Department of Planning and Environment

**Nepean Hospital Redevelopment Project - Stage 2 (SSD-16928008)
Response to Submissions**

ATTACHMENT 1 – ADDITIONAL KEY ISSUES

FACADE ELEVATION - SOUTH ELEVATION

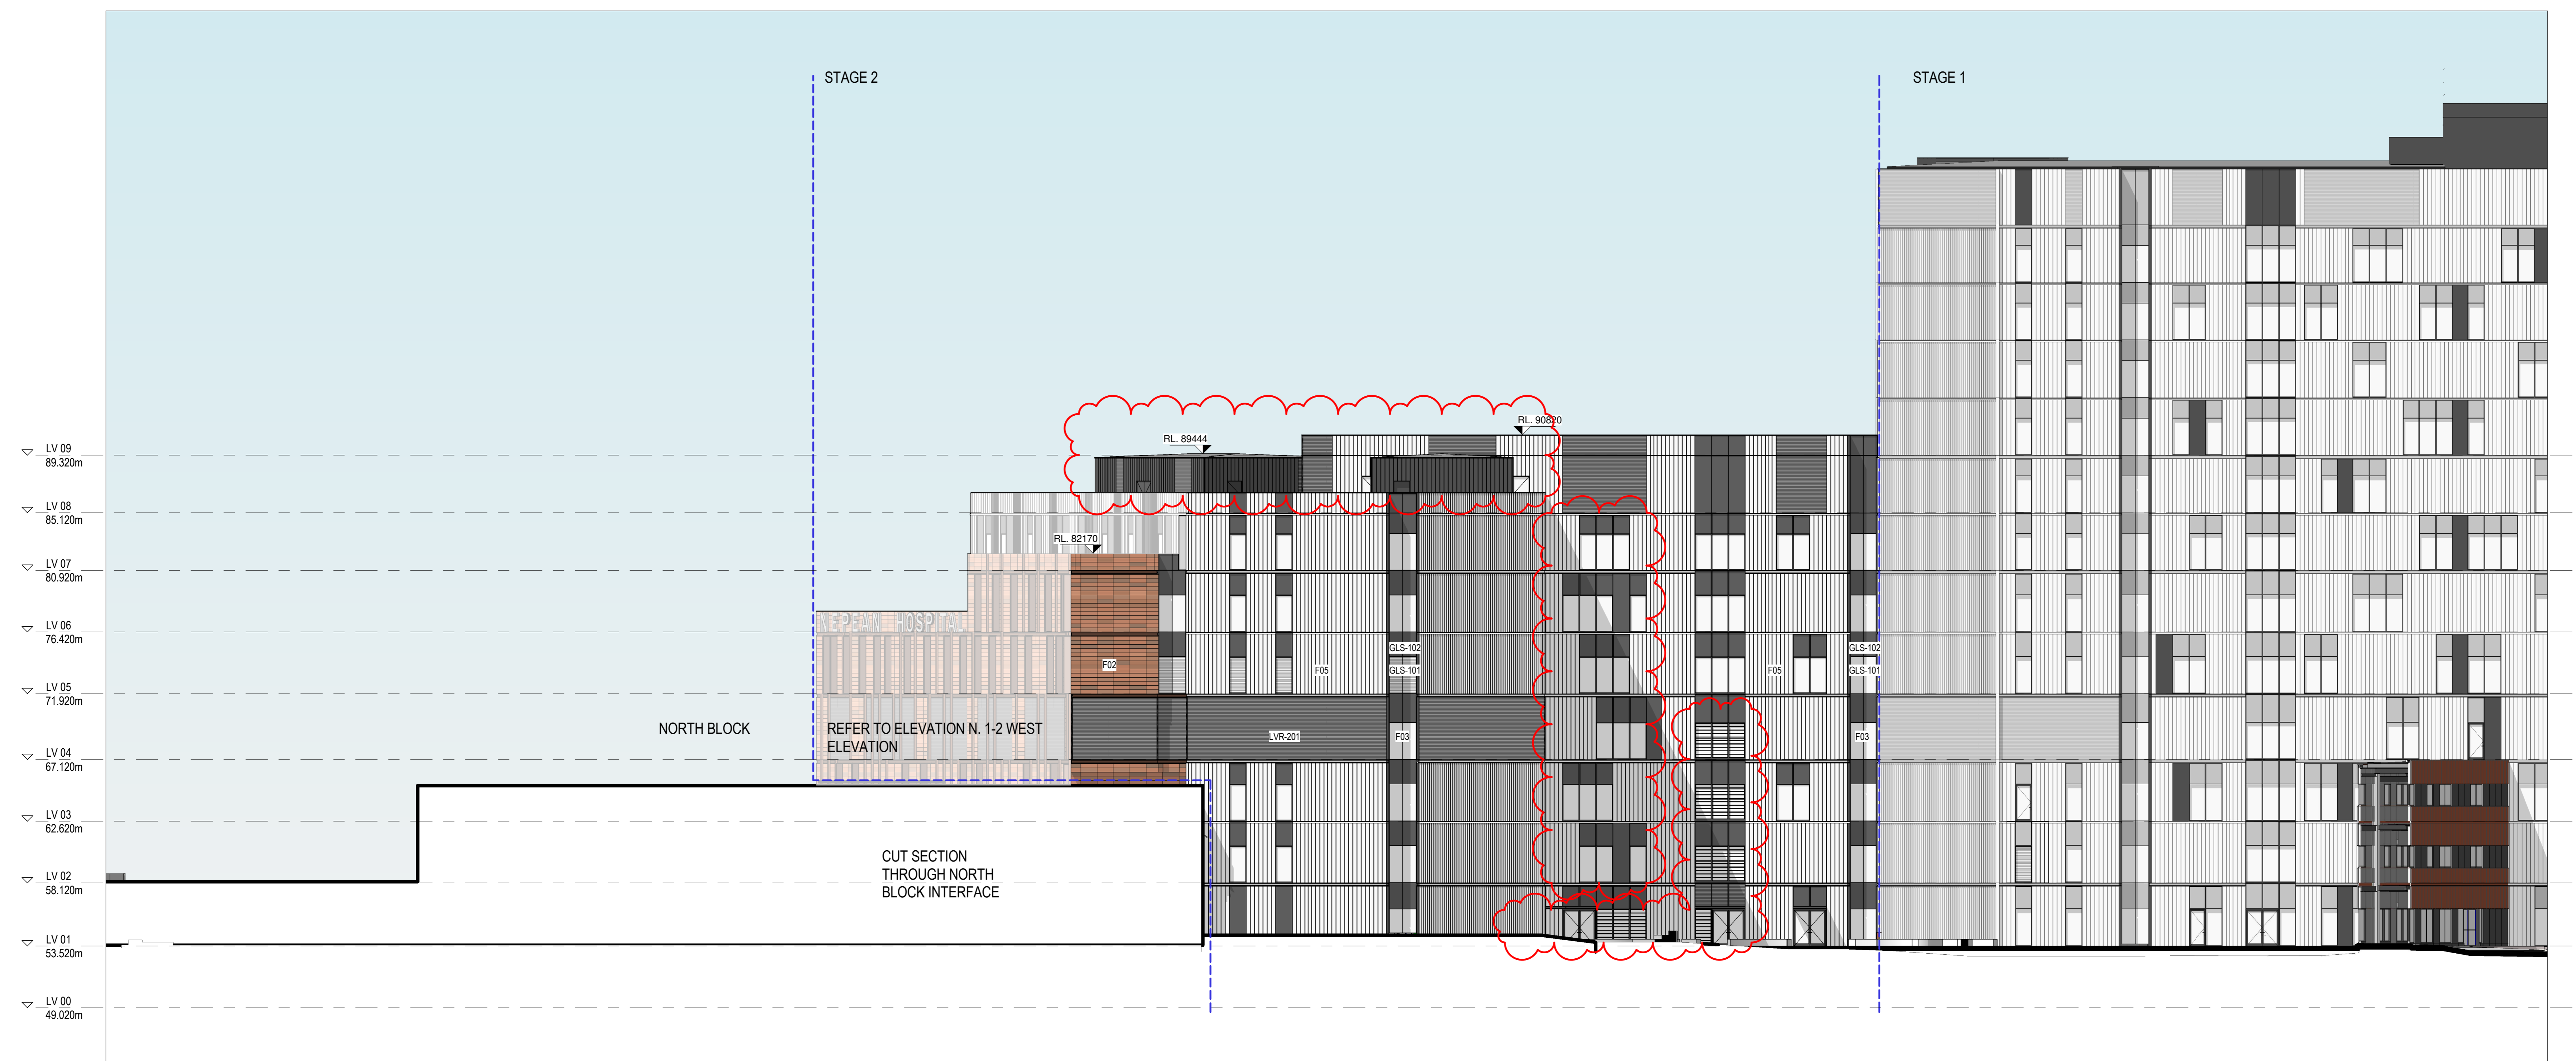
- the southern and eastern elevation plans depict facades that would benefit from the use of colour or material change to create visual articulation of the building bulk similar to the eastern facade. Consideration should be given to integrating colour and altering materials to create visible building articulation and to break up the blank facade.
- the plans are to be amended to include screens for the rooftop plant and utilities to minimise the visual impact of these structures.
